DEVELOPMENT REVIEW BOARD
TRANSPORTATION DEVELOPMENT

DRB Project Number: 1011479
2406 Mountain NW

SUBJECT: Preliminary/ Final Plat, Design Variance

DRB Project Number: 1011479 Hearing Date: 03-21-2018
 Project: Tracts 242A, 242B, & 242C, MRGCD Map 38 Agenda Item No: 7

SKETCH PLAT OF TractS 242A, 242B, AND 242C

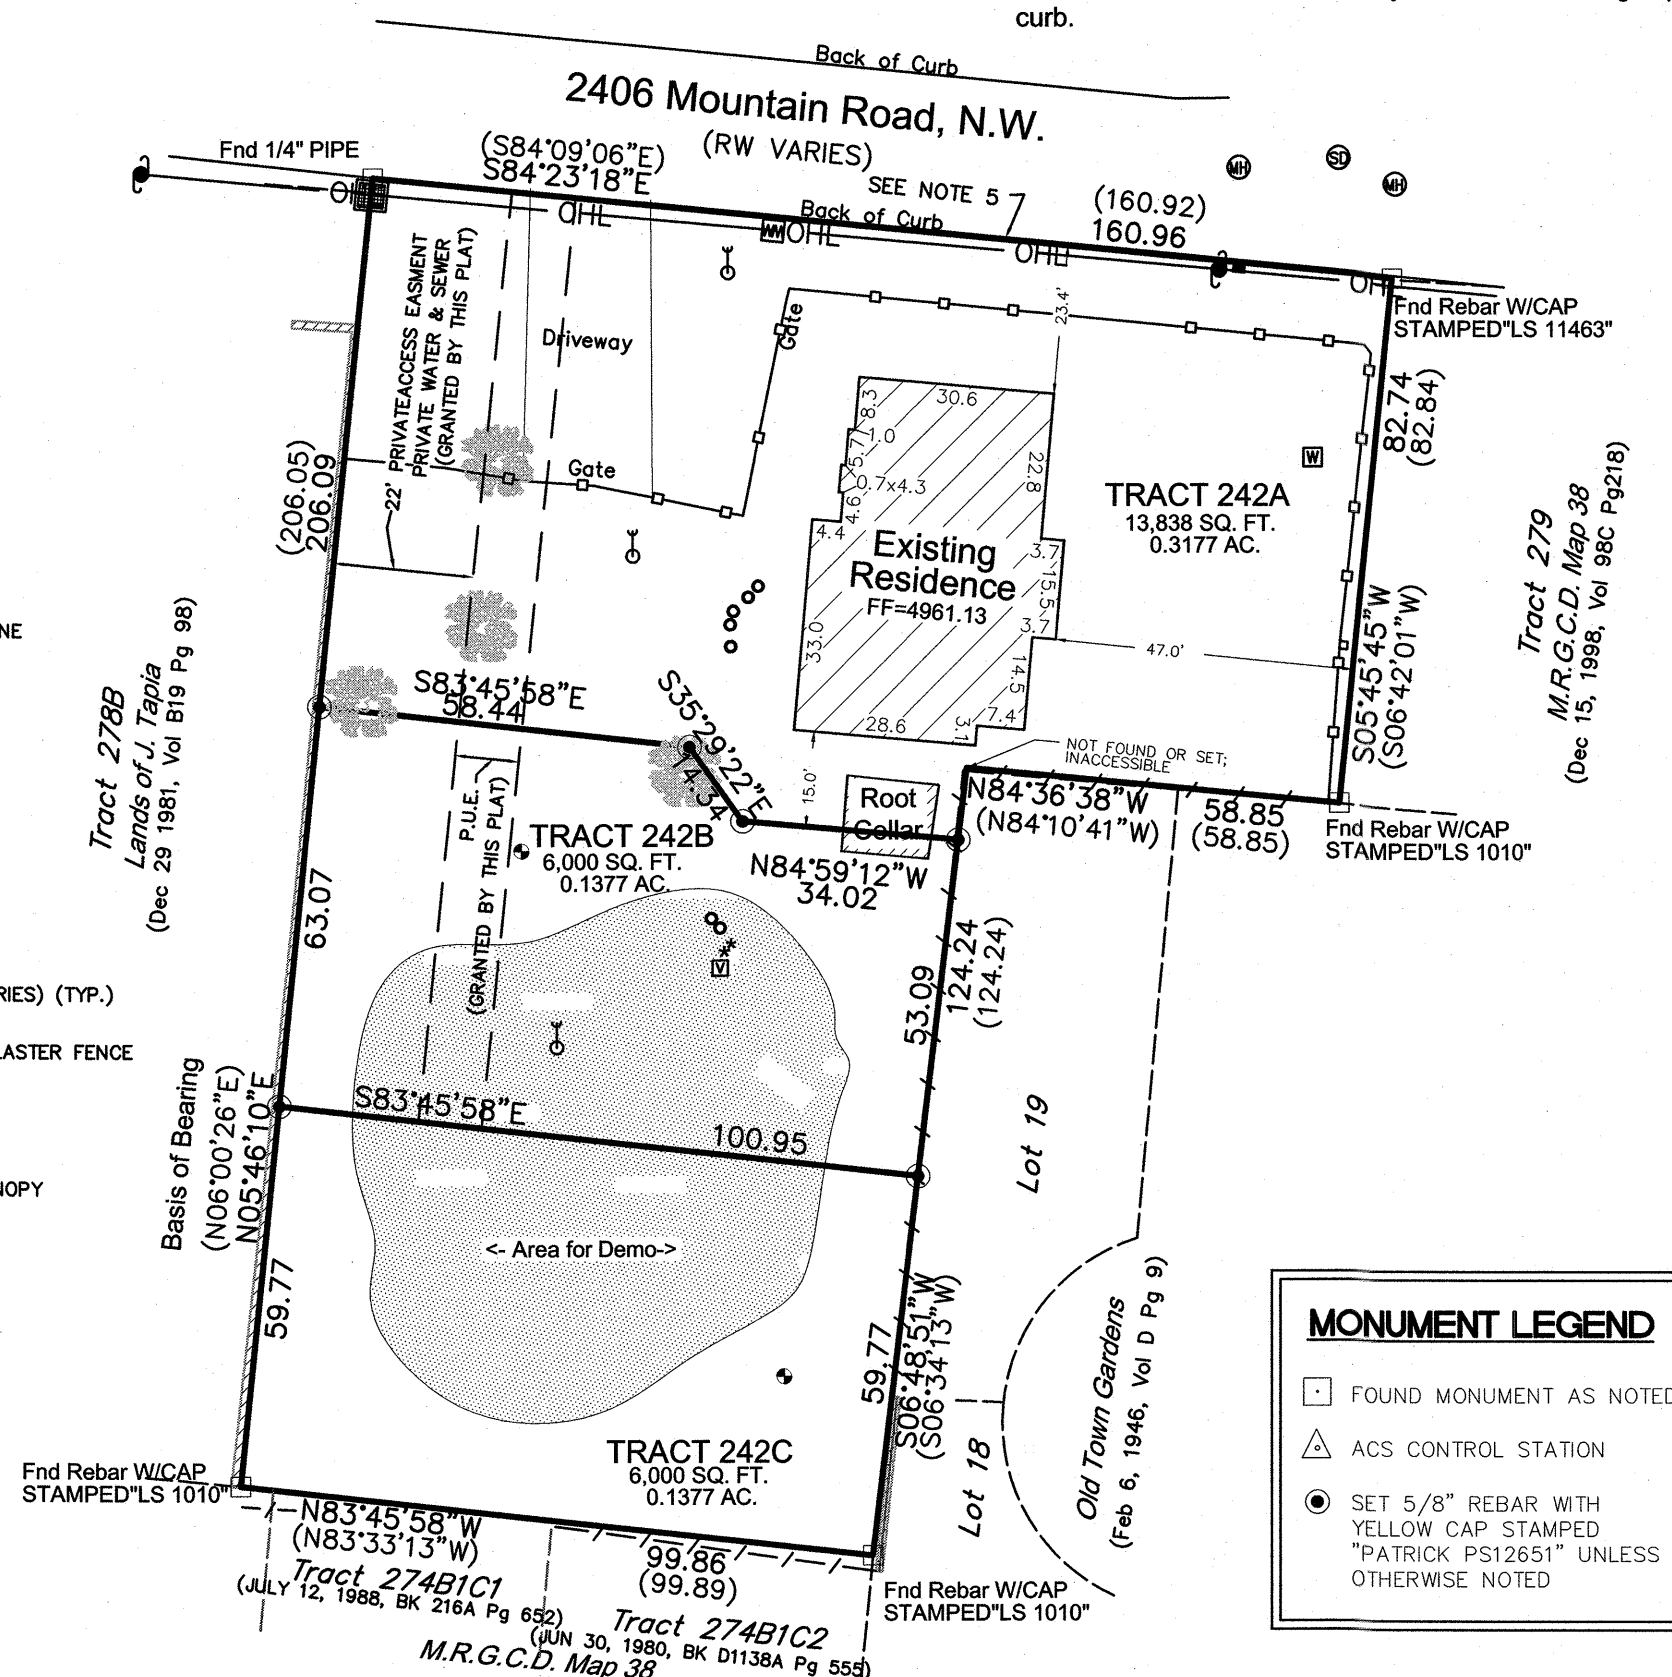
1. A min. 4' wide sidewalk and 22' wide gravel access road with initial 25' paved with minimum 2" asphalt per DPM Table 23.2.2 will be required at building permit.
